**Re: Phase 1 Bedrock at The Trails by La Terra Development at 9300 Woodmont Ave. NW  
Erosion and Sediment Control Plan for Tracts 4 and 5 of the Trails Unit 3A  
Engineer's Stamp Date 4/4/24 (C09E011B)**

Based on the information in your submittal, received on 4/4/24, the above-referenced ESC Plan cannot be approved for a Work Order and Building Permit until the following comments are addressed.

TYPICAL CONCRETE WASHOUT-BELOW GRADE

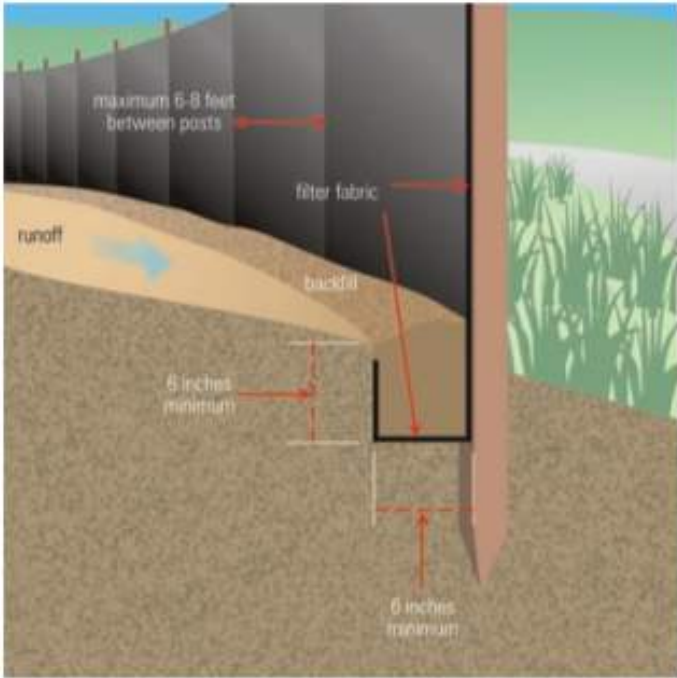
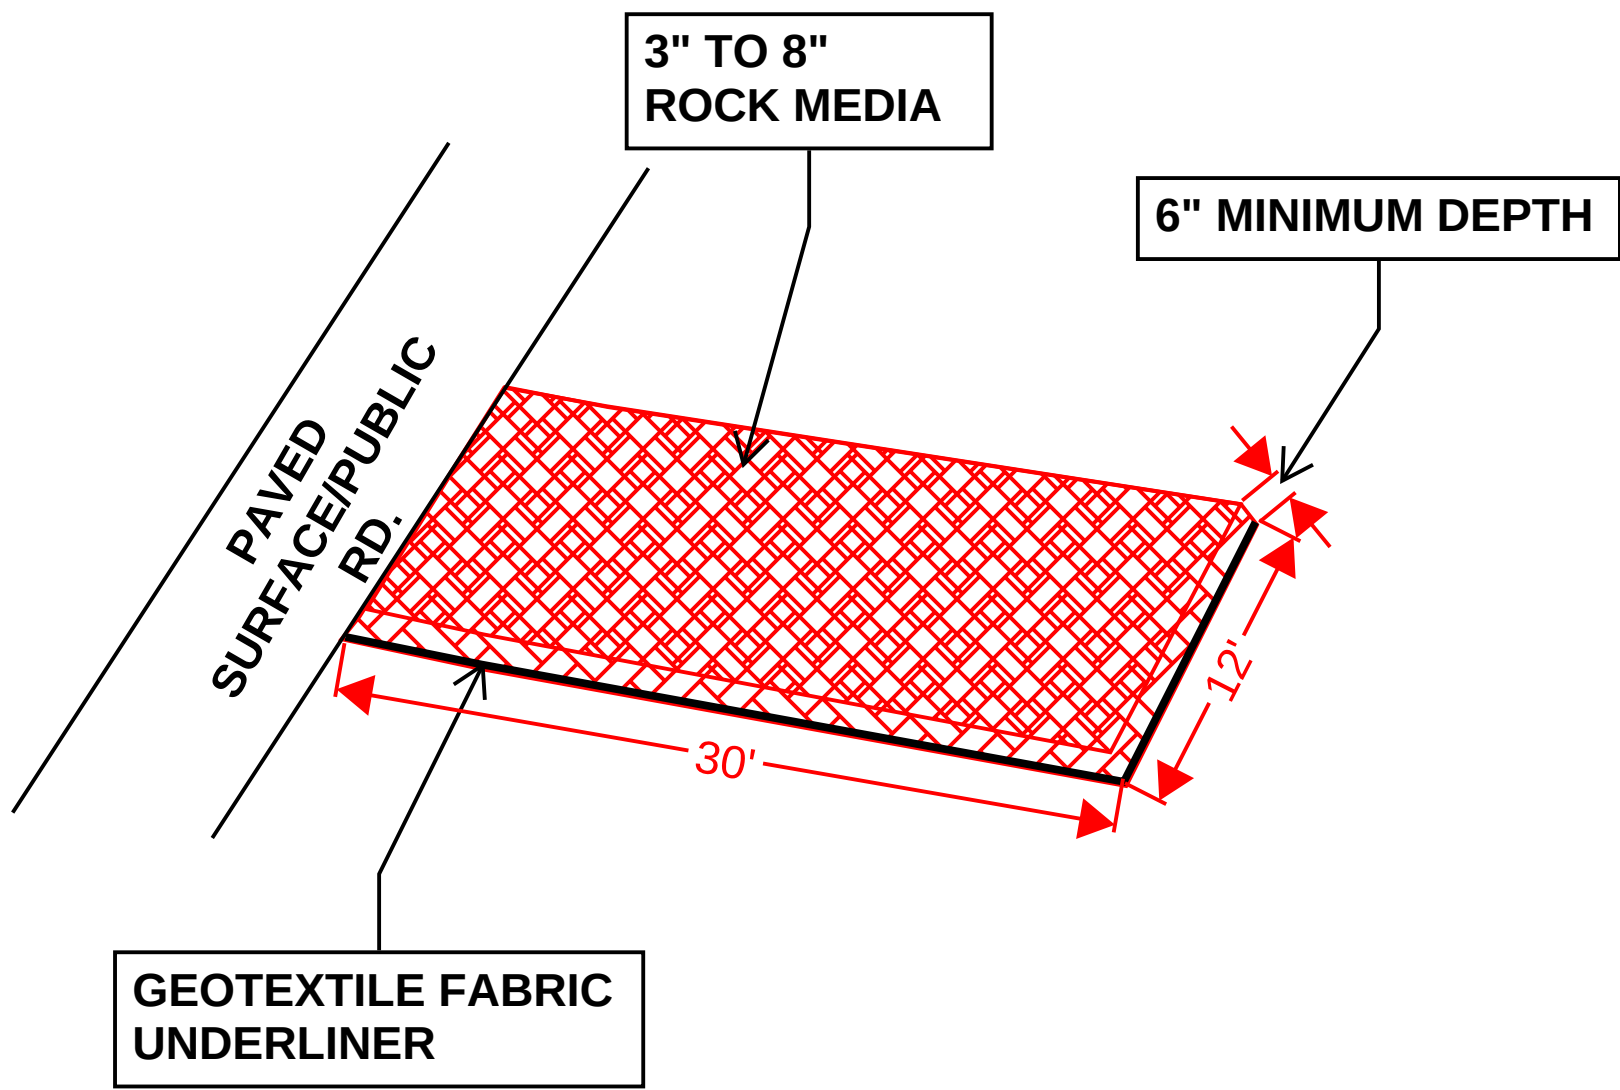
5. The inspection and maintenance specifications for the temporary sediment basins and the concrete washout on the detail sheet ESC-2 are missing and must be added per CGP 9.6.1c.i.

BEDROCK
TEMPORARY EROSION AND SEDIMENT CONTROL PLAN

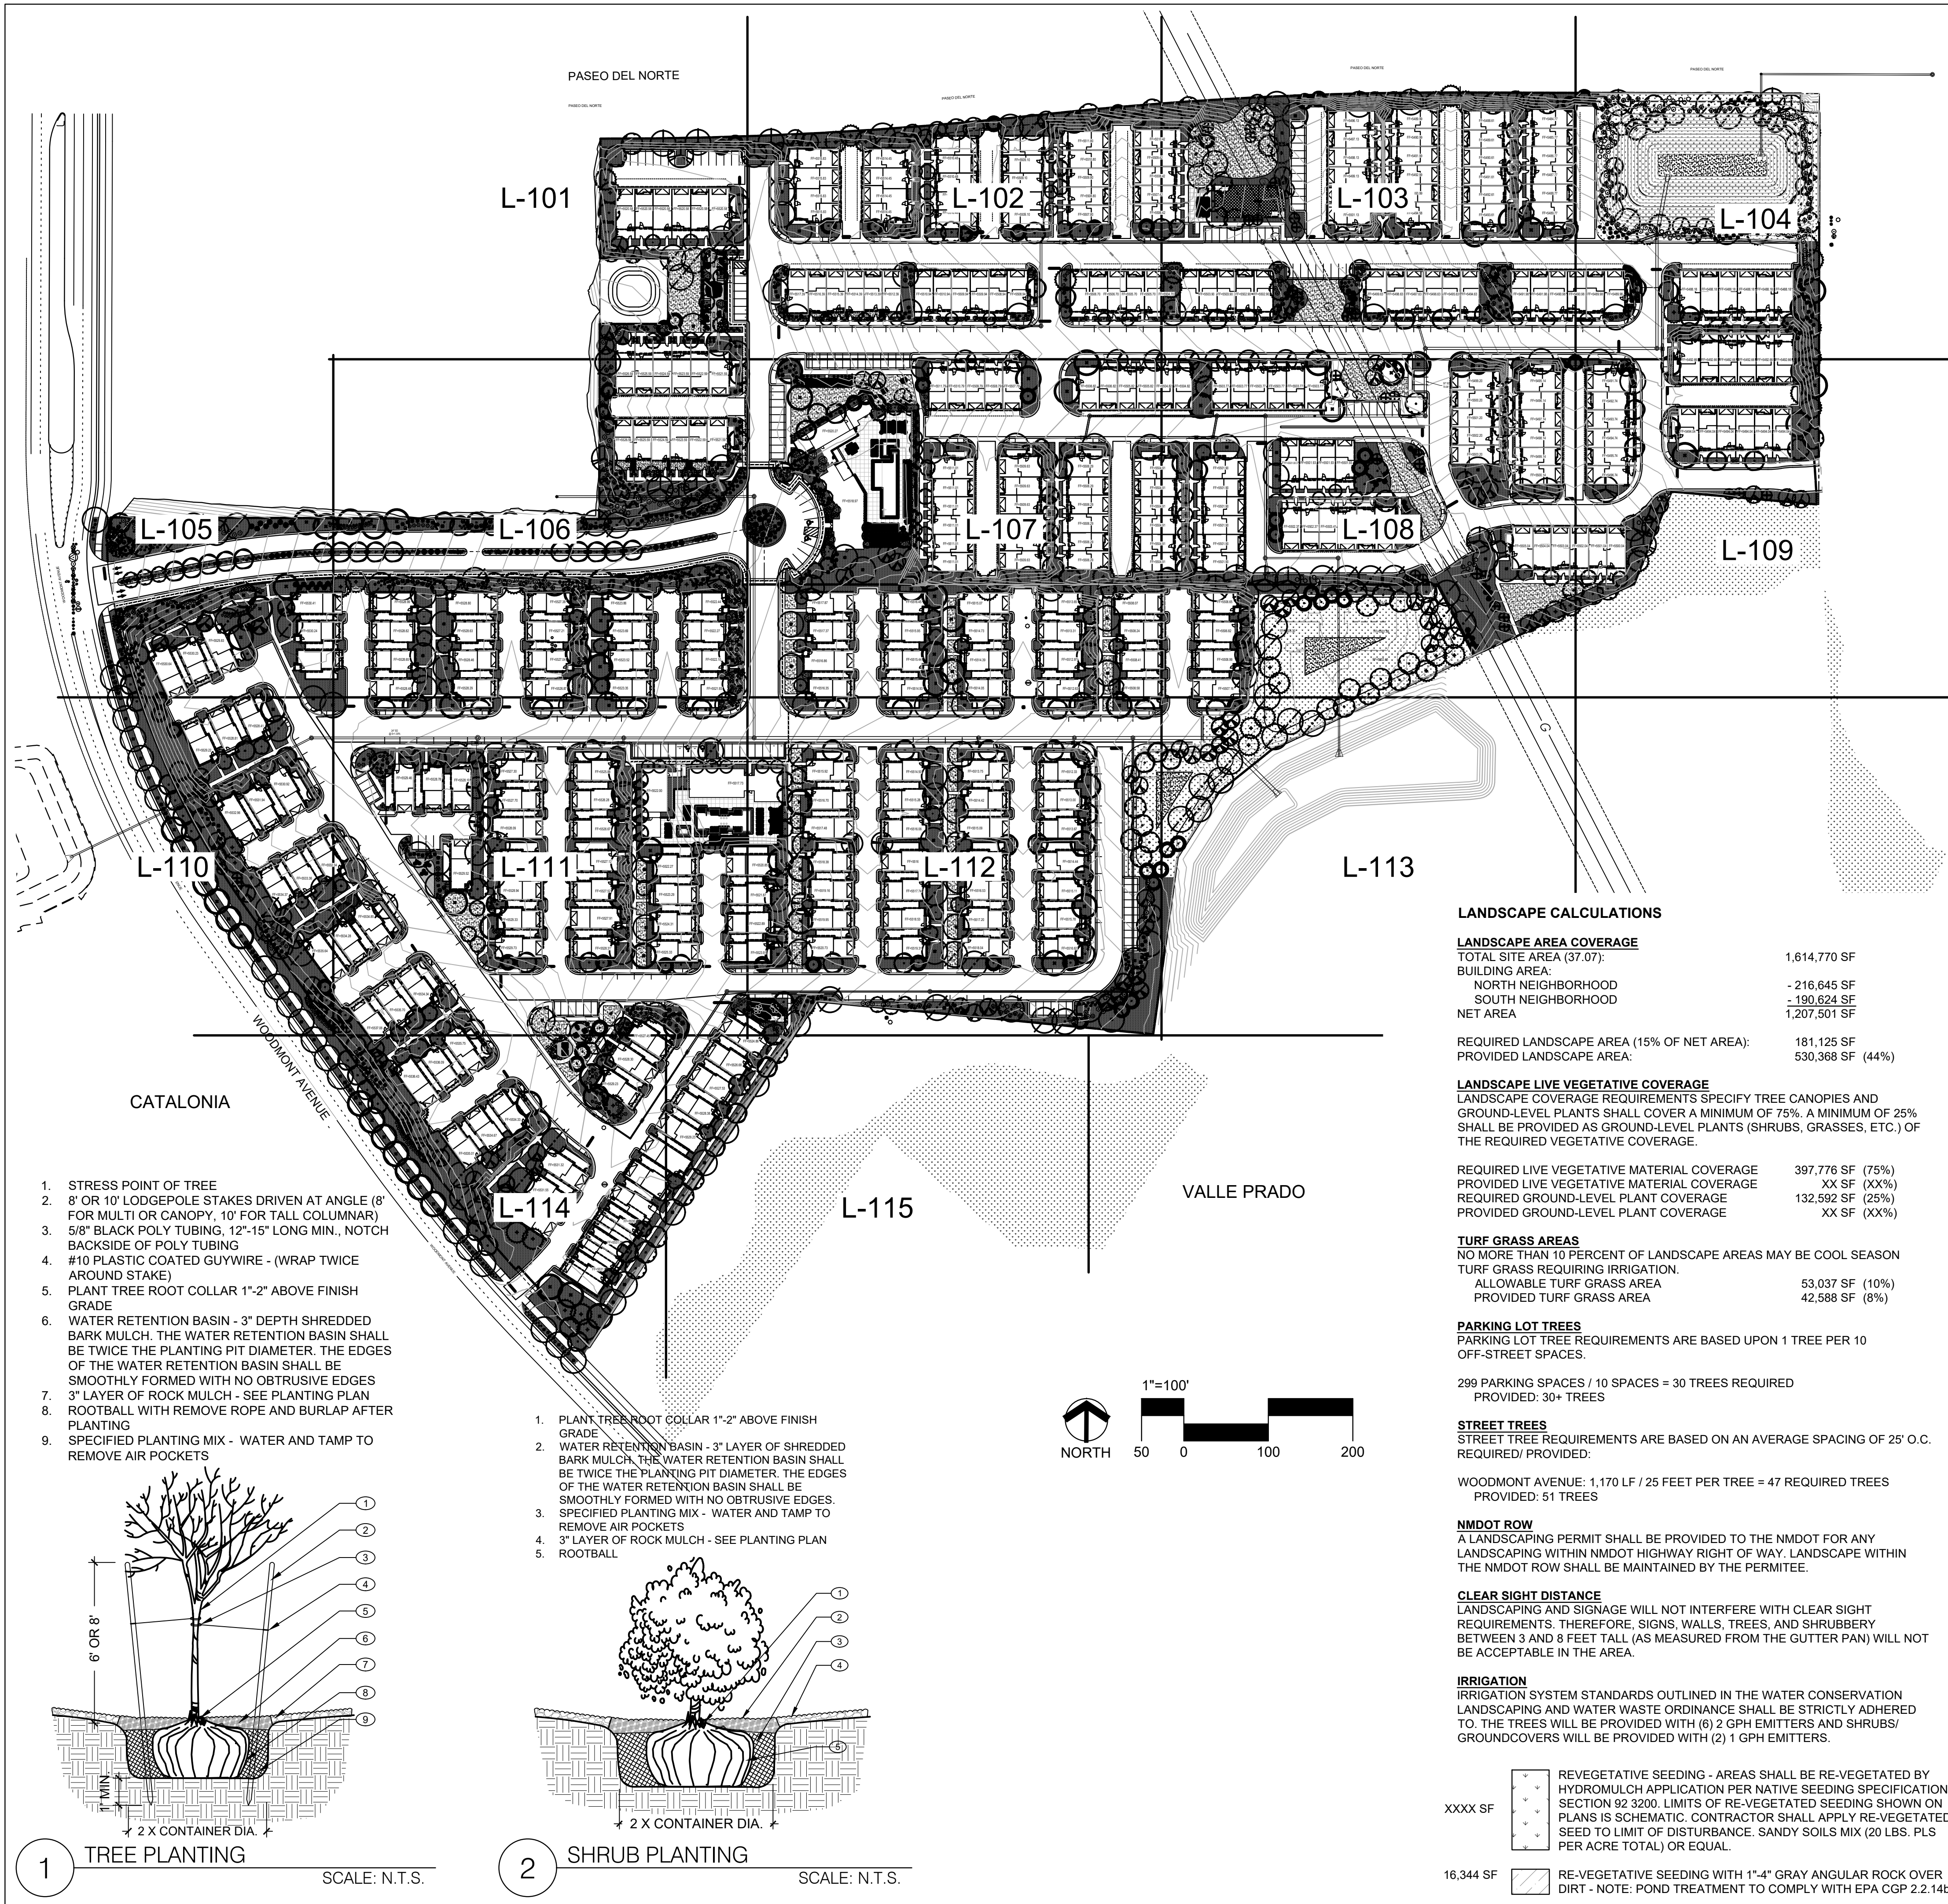
6. The width of the land disturbance for the waterline on Tract OS-2 appears to be much larger than the easement. Please label the width of the disturbance and add fencing to the ESC Plan and the Work Order Sheet 32 per City Standard Specification 1014.2.1. Also, stake out the location of the fence in the field so that it can be reviewed during a pre-grading meeting per Sec 1014.3.1.2(attached). Identify the easement for the waterline on the ESC Plan and Work Order sheet 32 and provide a copy of the document that created the easement.

7. It doesn't appear that Comment #5 in the letter dated 3/27/24 was addressed. Add a note on the ESC Plan stating that "the trail construction is not a part of this ESC Plan and a separate ESC Plan must be submitted to the SWQ Section for approval along with the property owner's NOI prior to any land disturbing activities in Tract OS-2. All land-disturbing activities associated with this development on Tract OS-2 will be stabilized with Native Seed with Aggregate Mulch per City STD SPEC 1012 or approved equal as may be required by the property owner."
